**KIRKLEES METROPOLITAN COUNCIL
INVESTMENT & REGENERATION SERVICE**

DELEGATED DECISION TO DETERMINE PLANNING APPLICATIONS

Reference No:	2025/62/90718/E
Site Address:	61, Carr Side Crescent, Batley, WF17 7JW
Description:	External alterations from brick to render finish
Recommending Officer:	Jennifer Booth

DECISION - REFUSE

PROPOSED FRONT ELEVATION  
Scale 1:50@A1

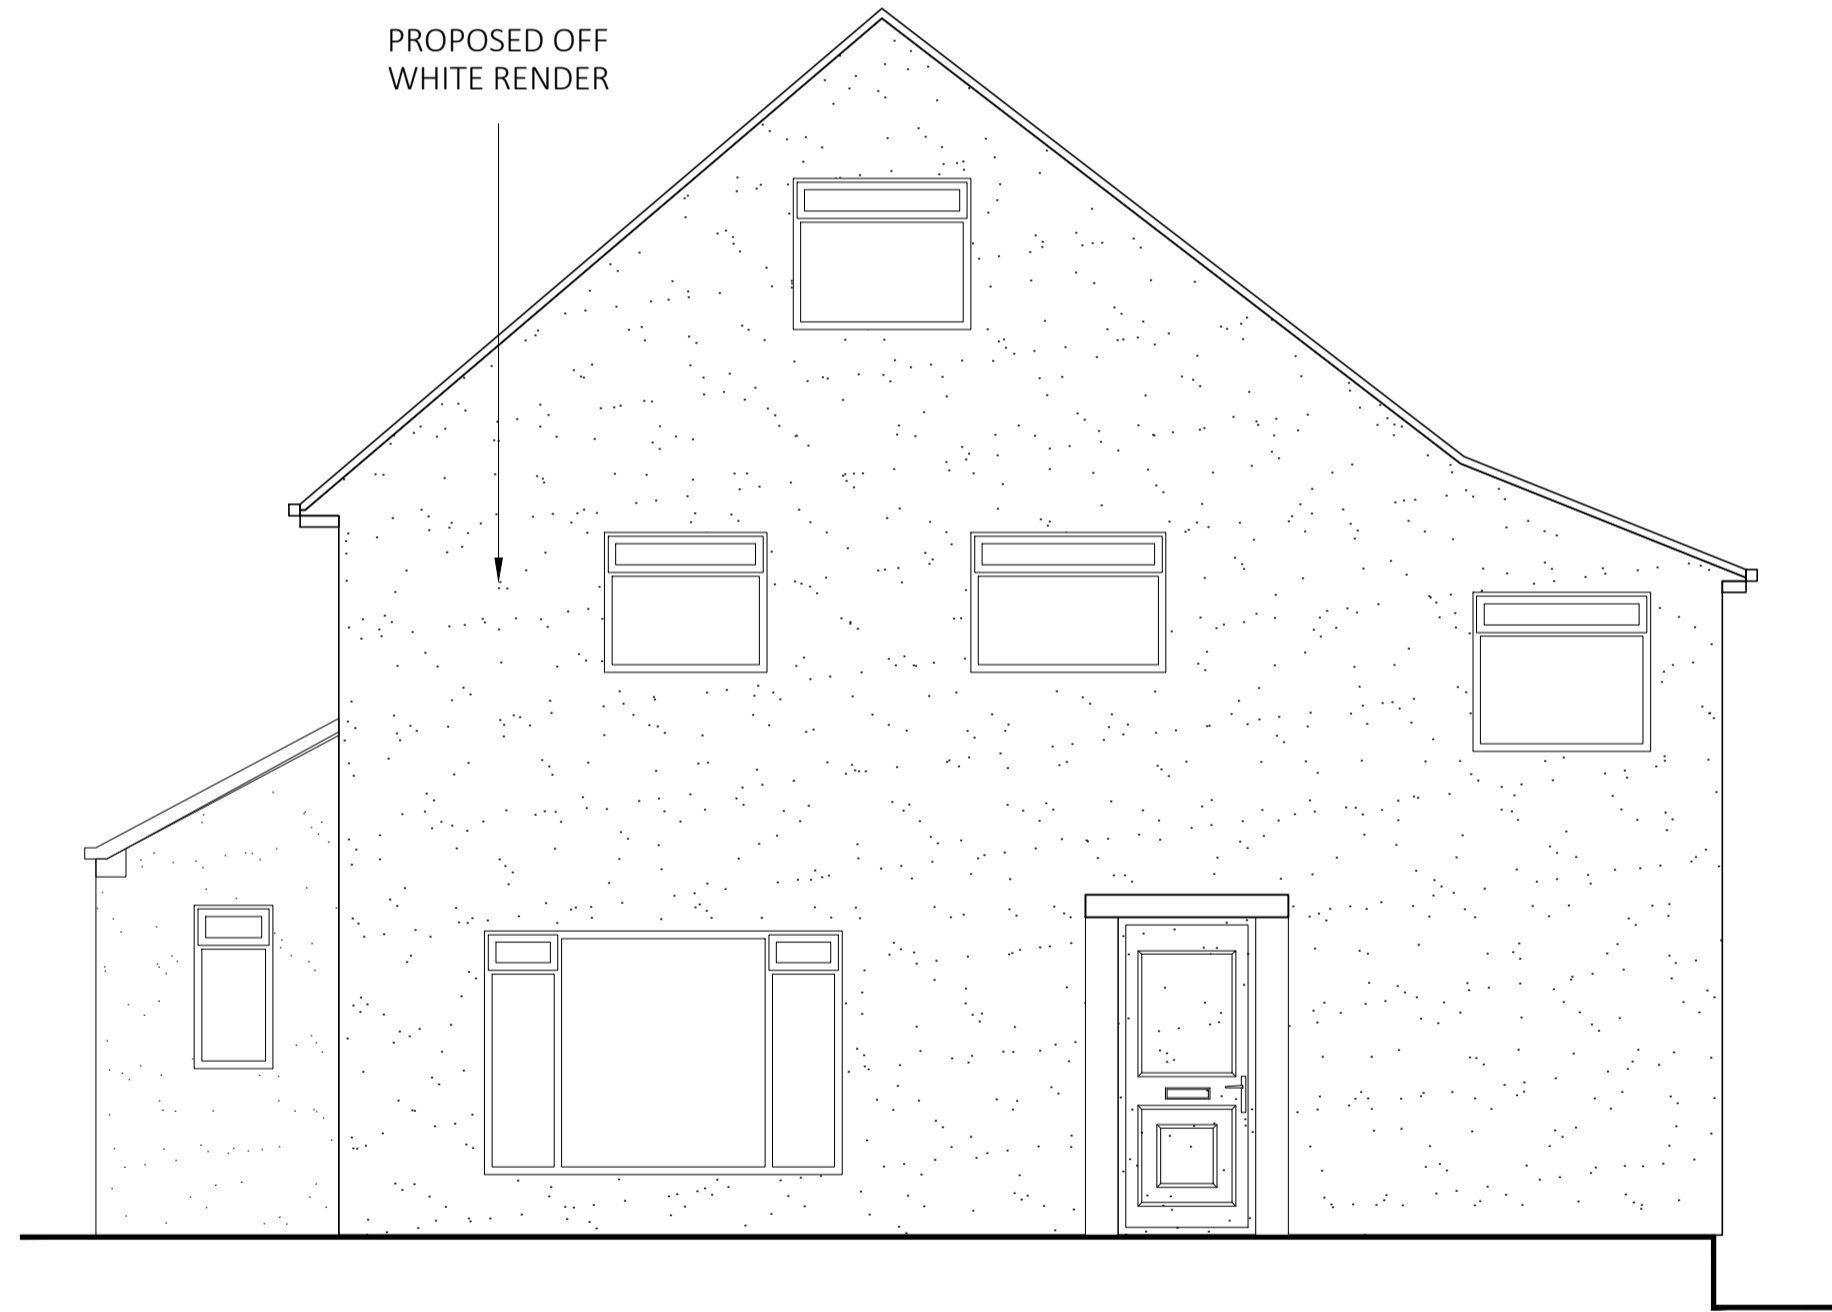
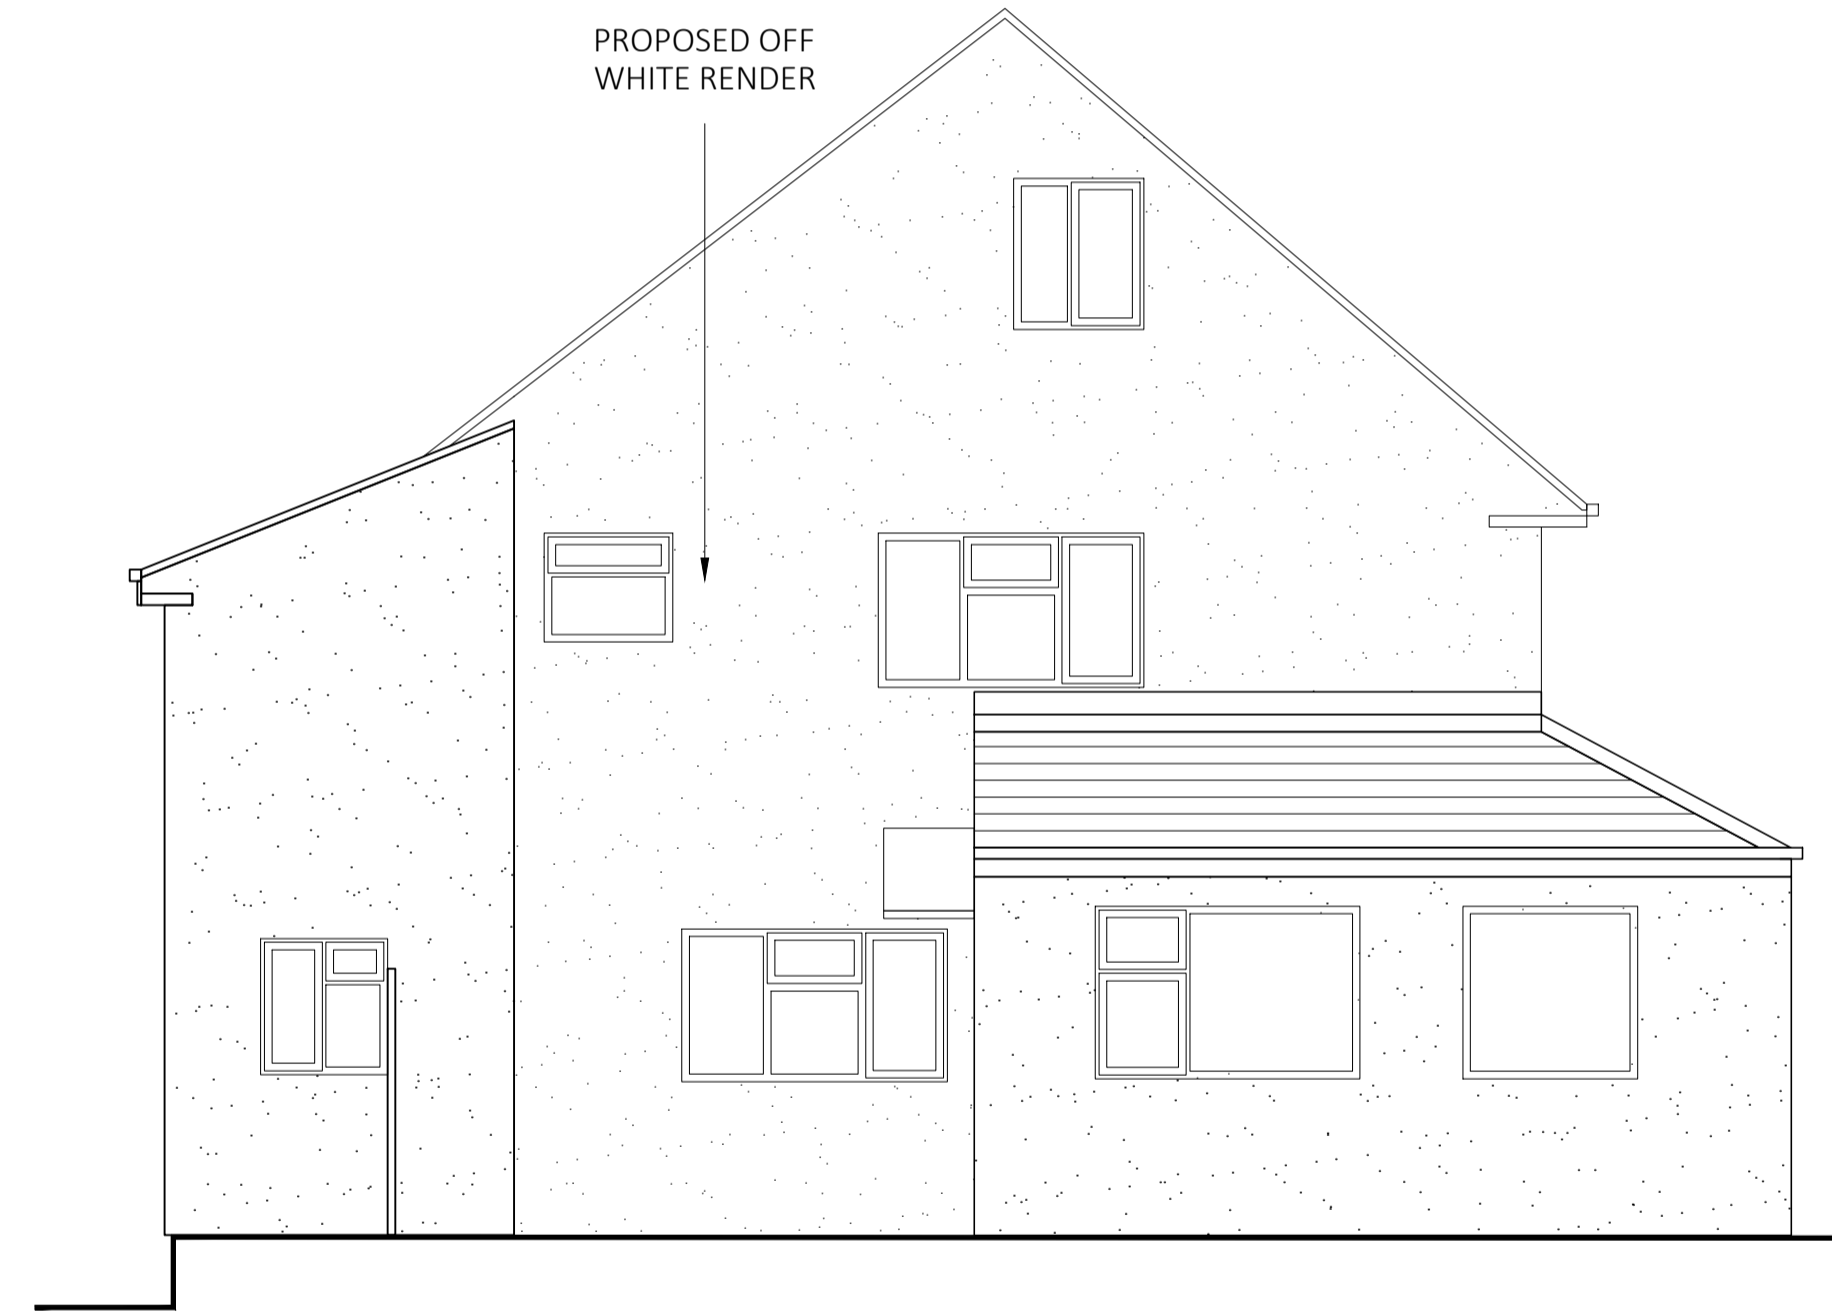
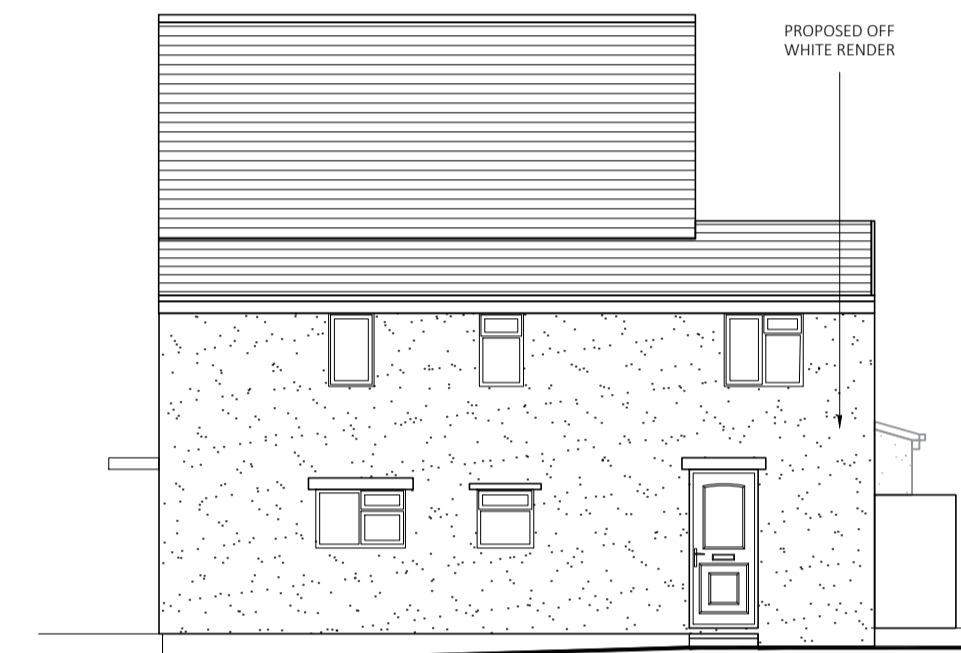
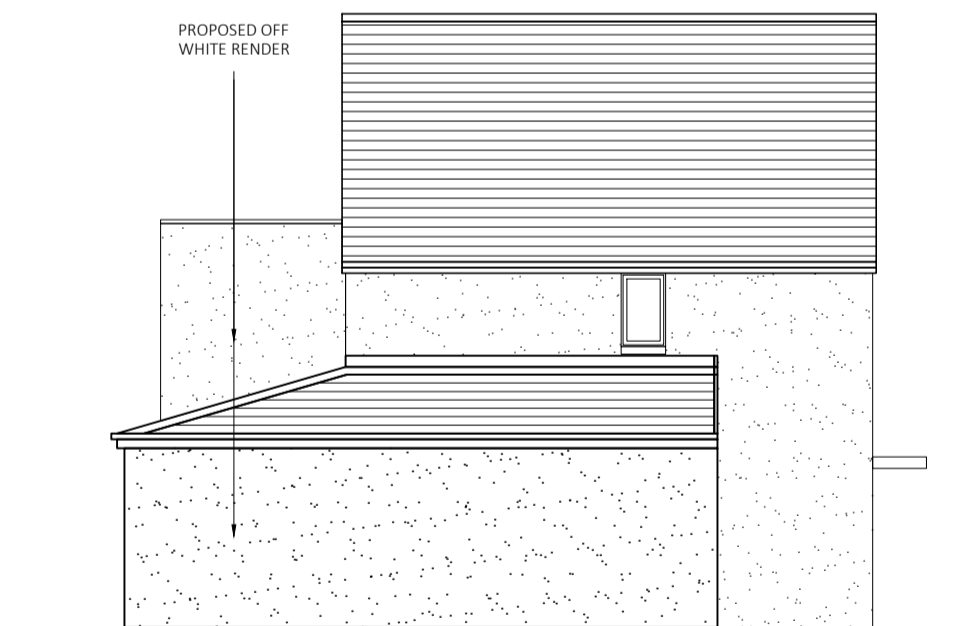
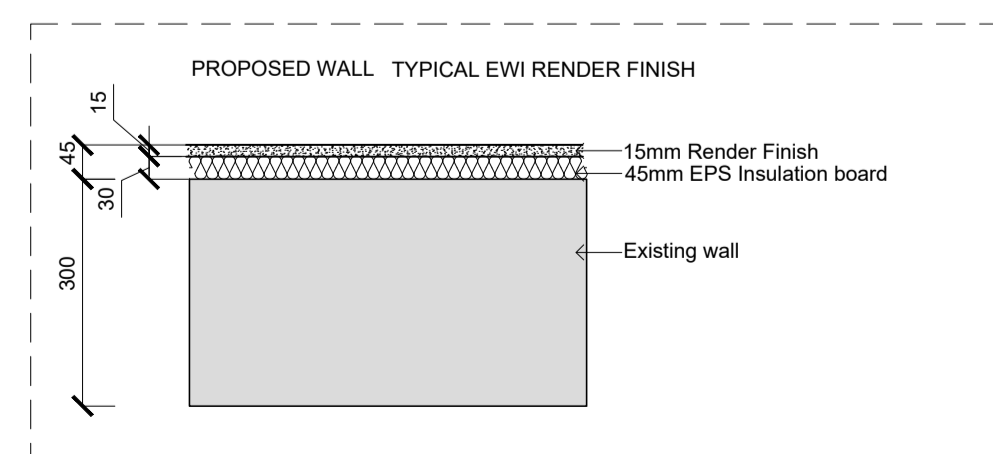
Carr Side Crescent is a residential street with properties of a similar age, apart from the host property which appears to be a more recent addition. The properties in the street have all been constructed using red brick with no affectations or accents in alternate materials. As such, for the host property to be rendered in its entirety would form an incongruous feature which would be out of character with the street. It is noted that the agent has supplied a design & access statement which states that the intention for the render is to provide additional insulation for the property and form a cohesive finish to the dwelling which has been extended previously. However, this is not considered to provide justification for the alien appearance which the property would have within the street scene upon completion. The proposed alteration of external facing materials is therefore not considered to have been adequately justified or to be acceptable in terms of visual amenity.

Having taken the above into account, the proposals would result in the formation of an incongruous development in terms of materials and would be

out of character with the properties on Carr Side Crescent. The proposals therefore fail to comply with Policy LP24 of the Kirklees Local Plan (a) in terms of the form, scale and layout, KDP 1 & 2 of the House Extensions & Alterations SPD and the aims of chapter 12 of the National Planning Policy Framework.

The proposed application of render to the external elevations of 61 Carr Side Crescent would have a detrimental impact on the appearance of the dwelling, resulting in an incongruous feature within the street scene. To permit the proposals would be contrary to Policy LP24 of the Kirklees Local Plan, KDP1 of the House Extensions and Alterations SPD and advice within chapter 12 of the National Planning Policy Framework.
